STATE OF NORTH CAROLINA
DEPARTMENT OF TRANSPORTATION

Subject: **Request for Modification to the Regional General Permit Number 31, Section 401 Water Quality Certification, and Neuse Buffer Authorization for Improvements to Existing I-440 Beltline, from south of SR 1313 (Walnut Street) to north of SR 1728 (Wade Avenue), Wake County. WBS 35869.1.2. TIP U-2719**

Explanation of Permit Impact Site Modifications Being Requested

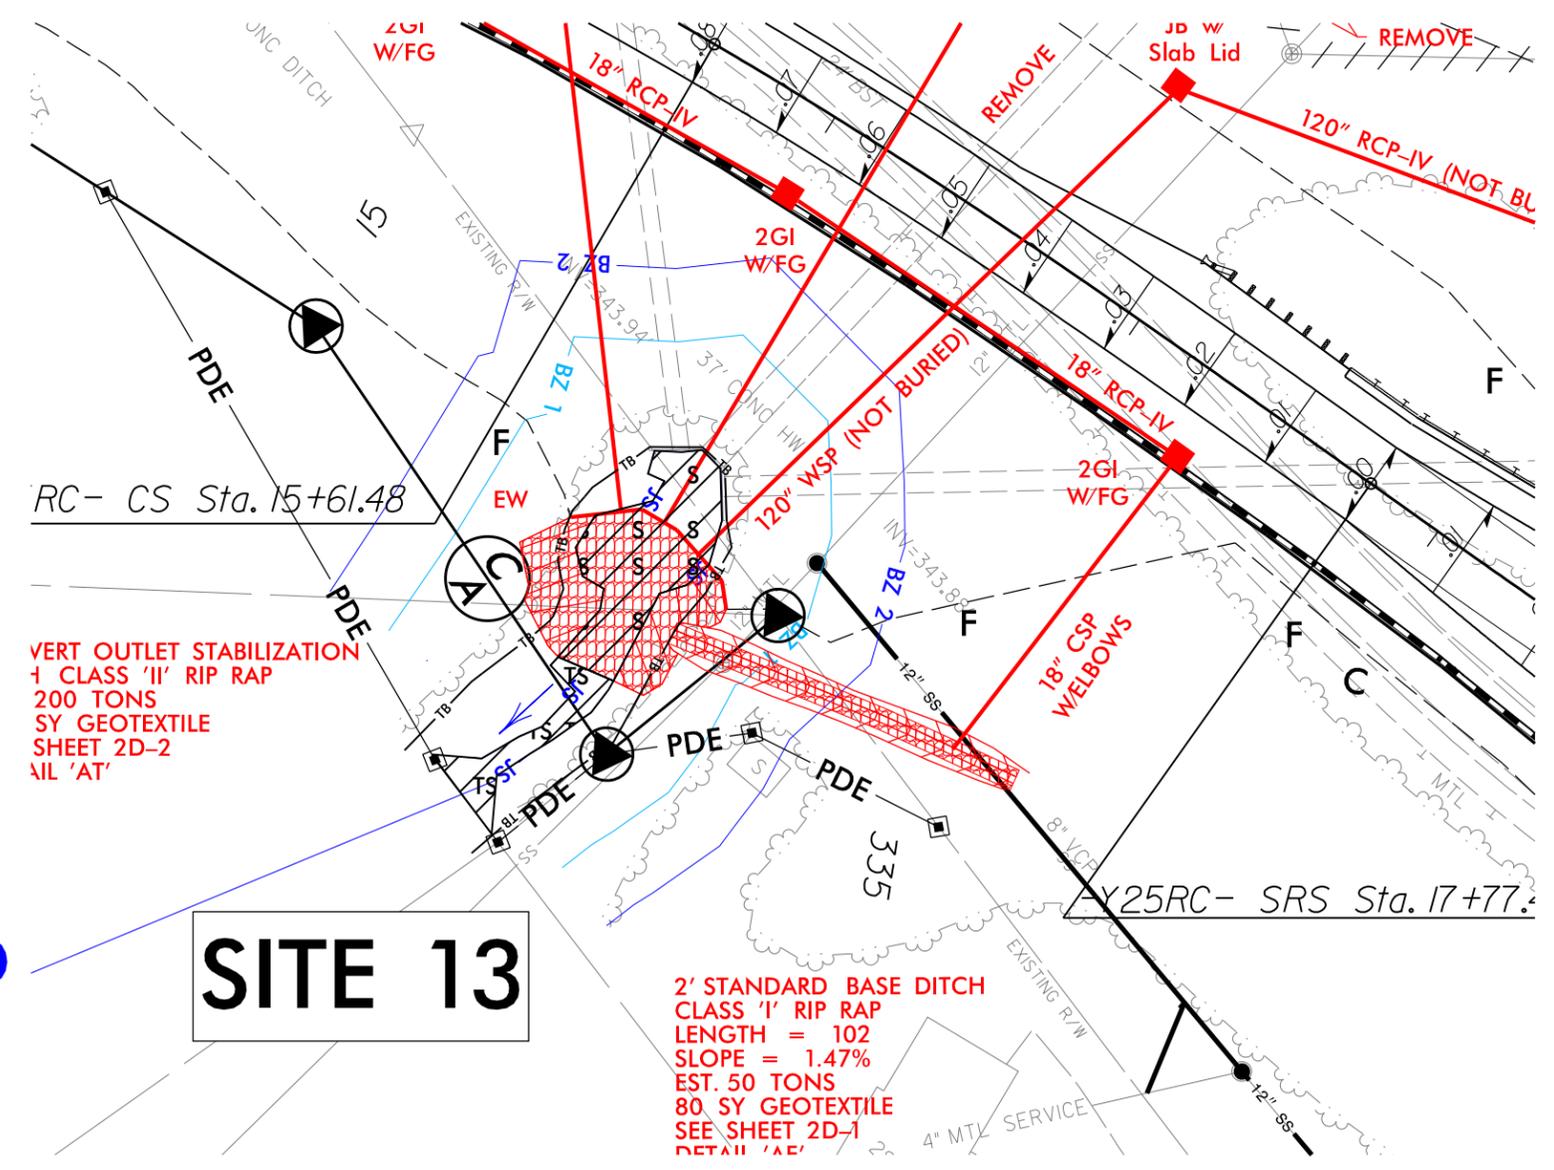
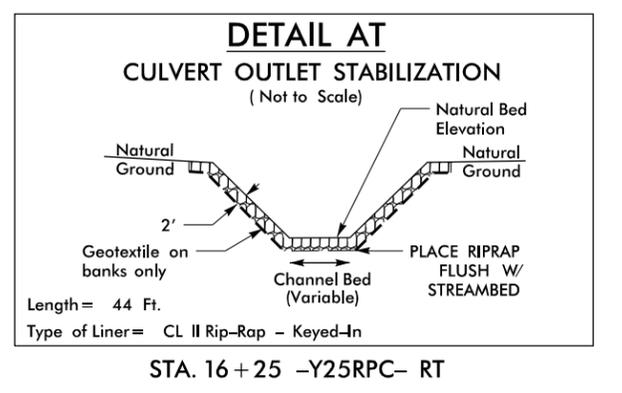
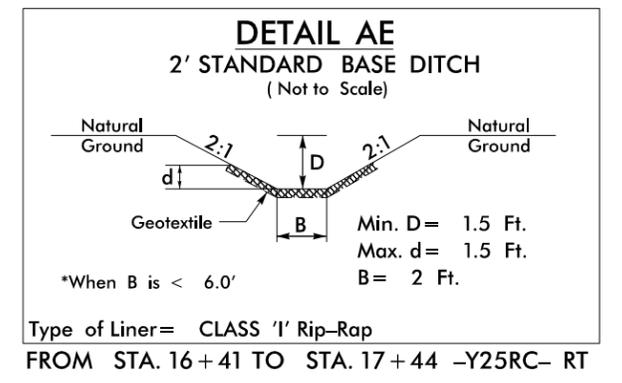
Site 13 (Sheet 17/17B) – Site 13 has a reduction in buffer impacts as a result of changing the PDE for a property owner who wanted to minimize impacts to an existing shed. The decrease in mitigable buffer impacts at Site 13 in Zone 1 is 913 sq ft and 1,569 sq ft in Zone 2. This makes the total allowable impact in Zone 1 7,989 sq ft and Zone 2 is 6,169 sq ft for Site 13.

PROJECT REFERENCE NO.	SHEET NO.
U-2719	18
RW SHEET NO.	
ROADWAY DESIGN ENGINEER	HYDRAULICS ENGINEER
<b>INCOMPLETE PLANS</b> DO NOT USE FOR R/W ACQUISITION	
<b>DOCUMENT NOT CONSIDERED FINAL</b> UNLESS ALL SIGNATURES COMPLETED

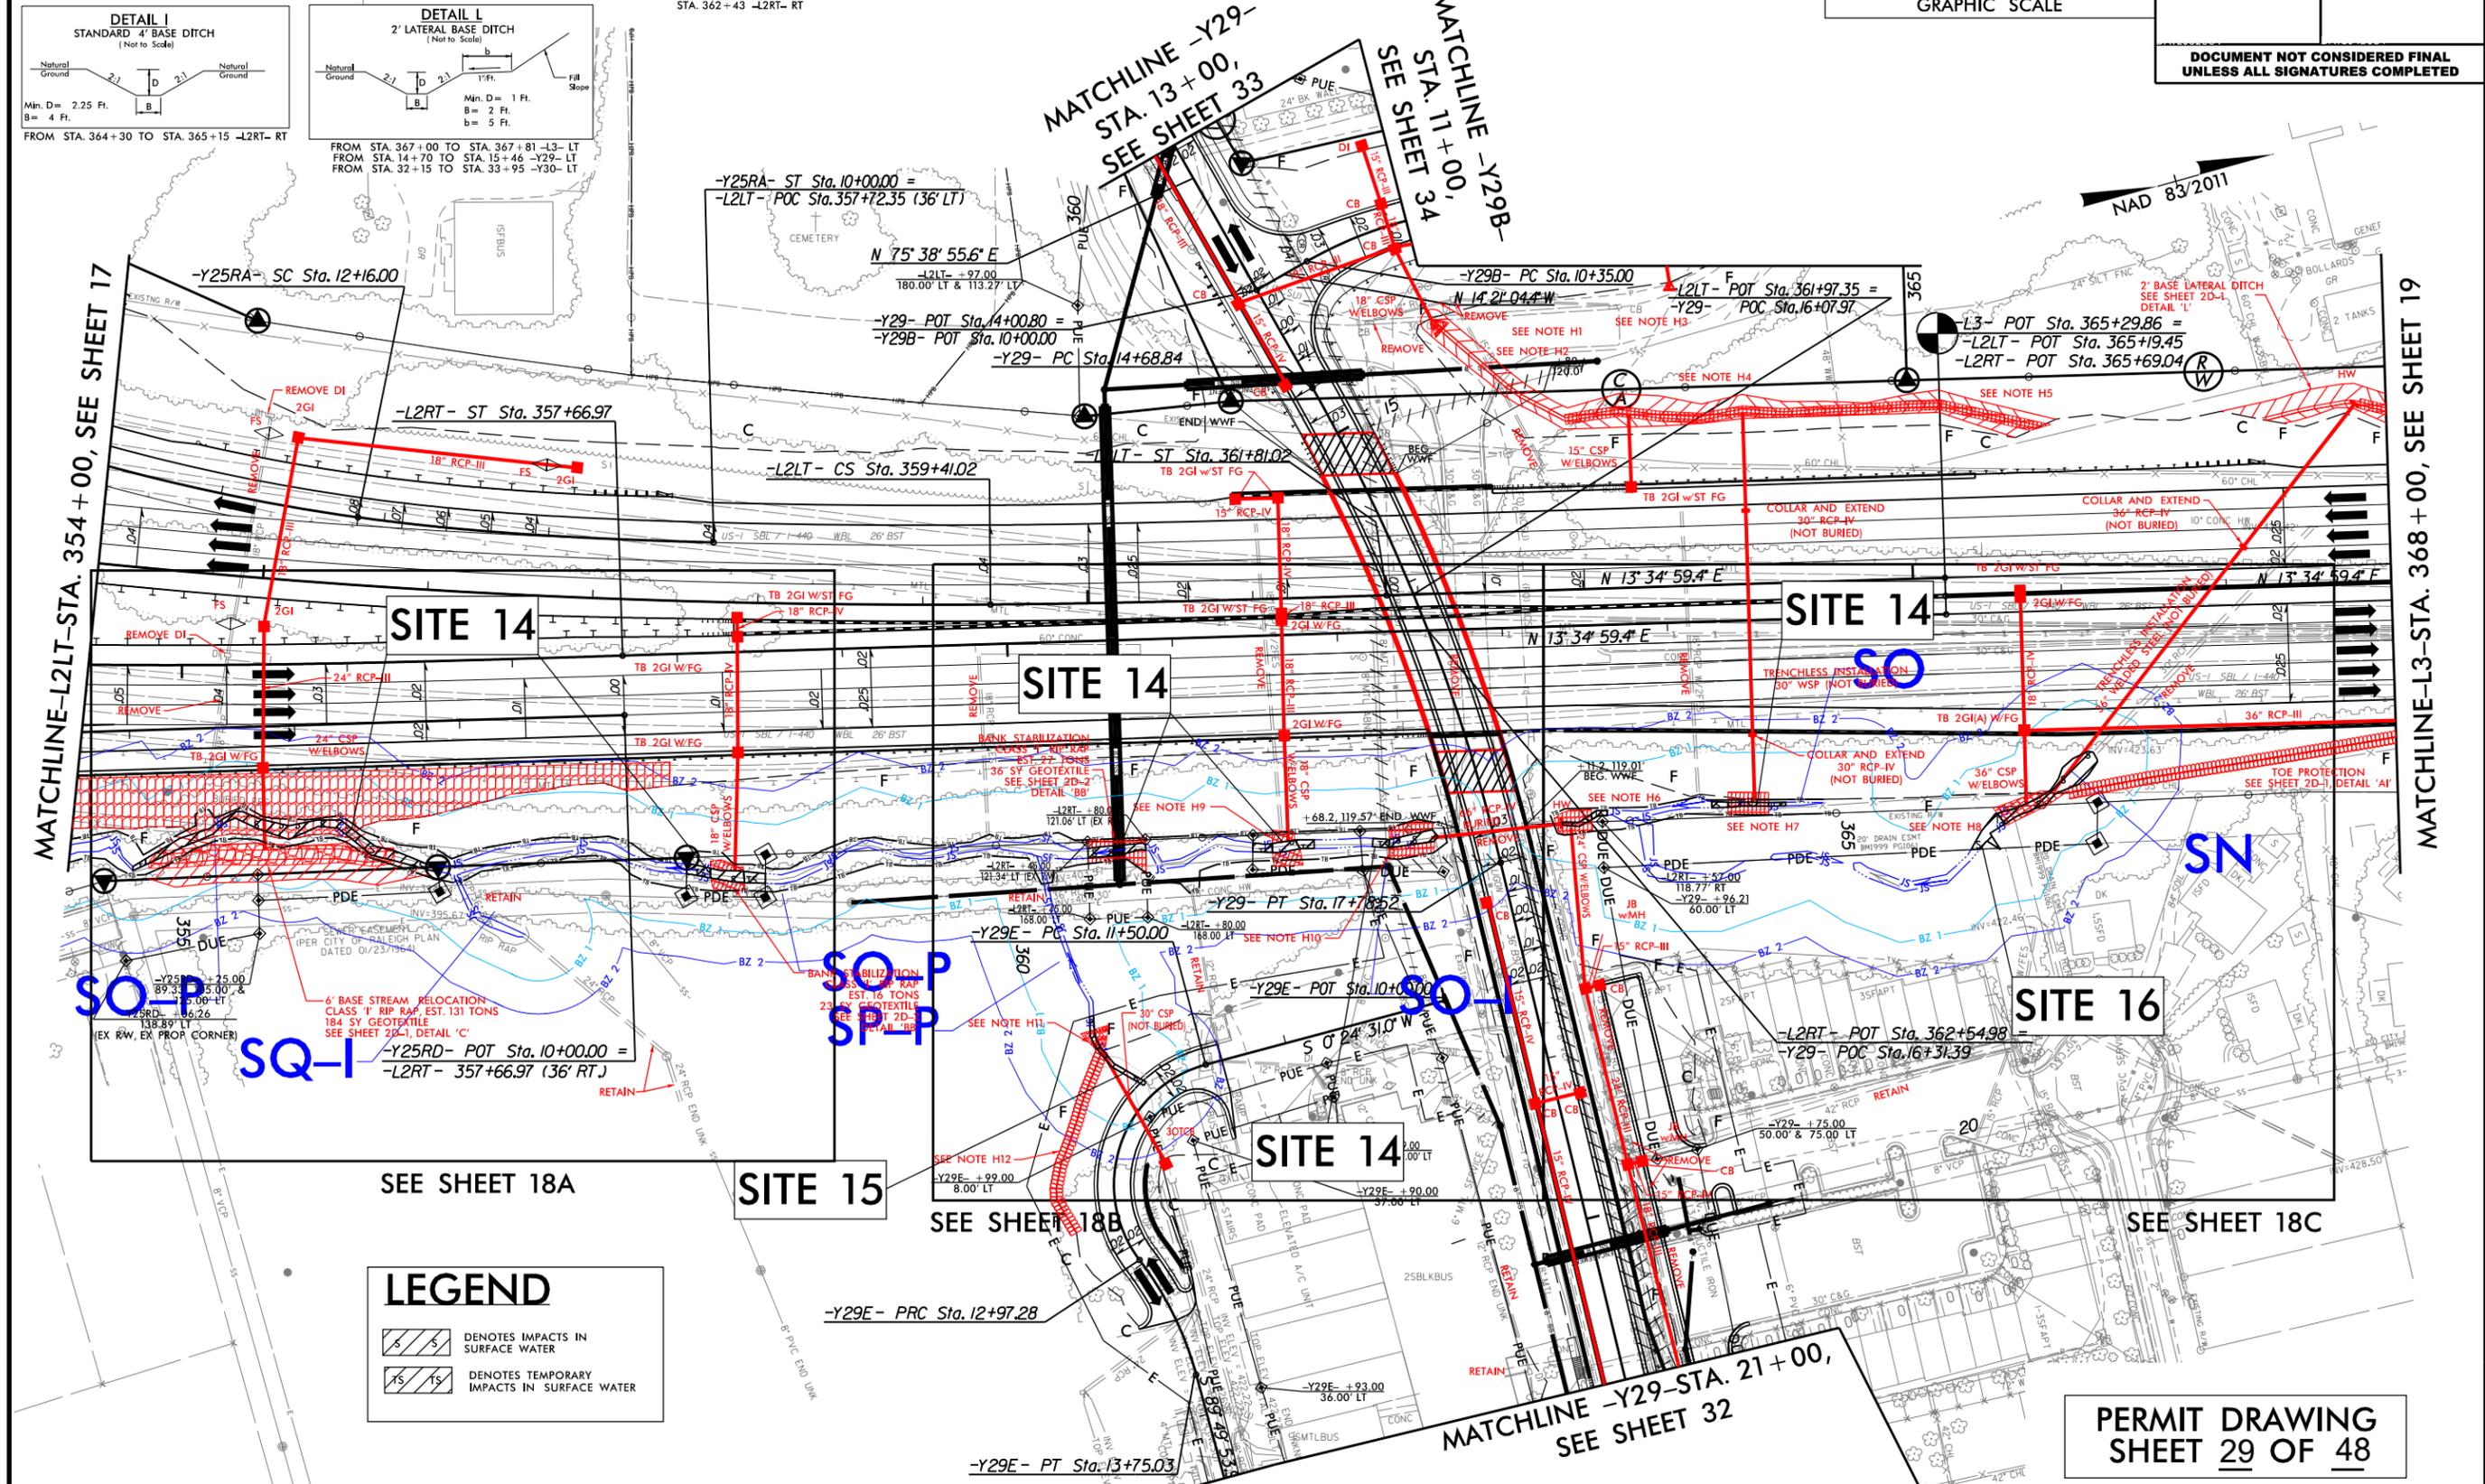
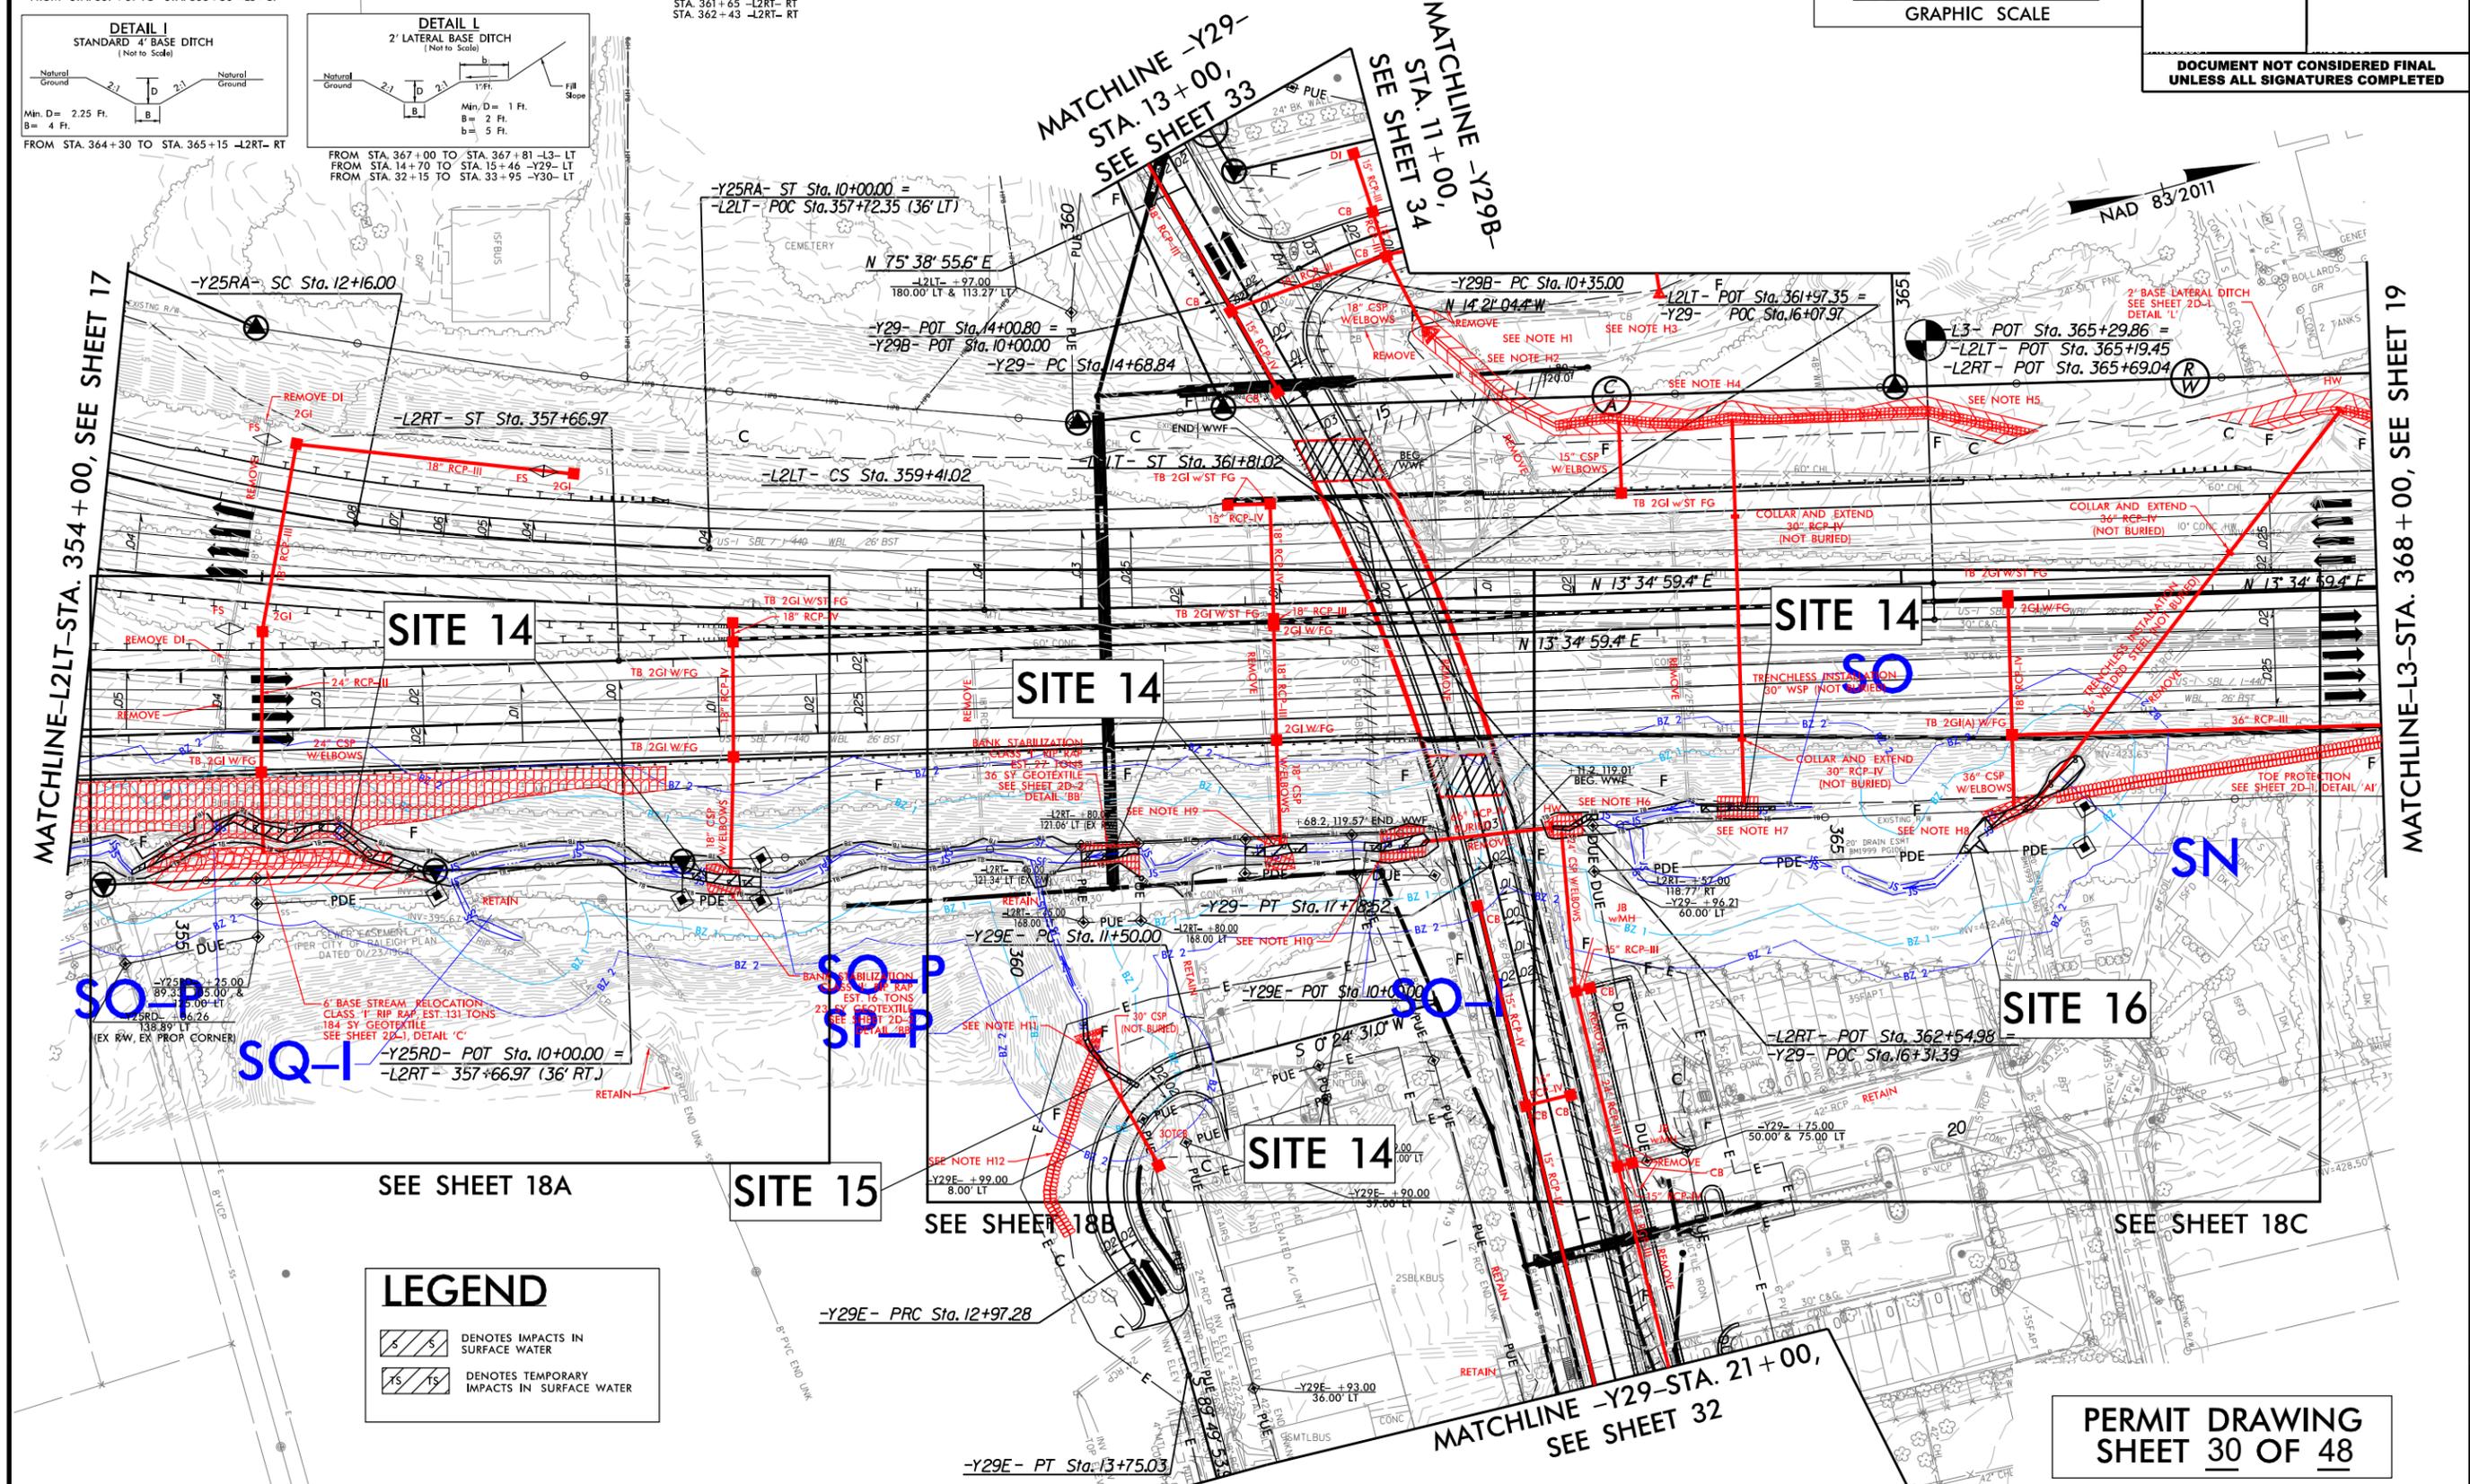
Site 14 (Sheet 18/18A) – Site 14 has an increase in permanent stream impacts and allowable buffer impacts due to a sewer line which will be bored under I-440. The increase in permanent stream impacts is due to bank stabilization being installed according to the utility recommendations. Bank stabilization impacts result in an additional 35 lf of permanent impact. Buffers will also be impacted by installation of the bank stabilization resulting in an additional 4,075 sq ft of impact in Zone 1 and 1,396 sq ft in Zone 2. This makes the total allowable impact in Zone 1 10,921 sq ft and Zone 2 is 2,780 sq ft for Site 14.

Site 15 (Sheet 18/18A) – Site 15 impacts did not change; however, the design has changed and is visible on the revised drawing.
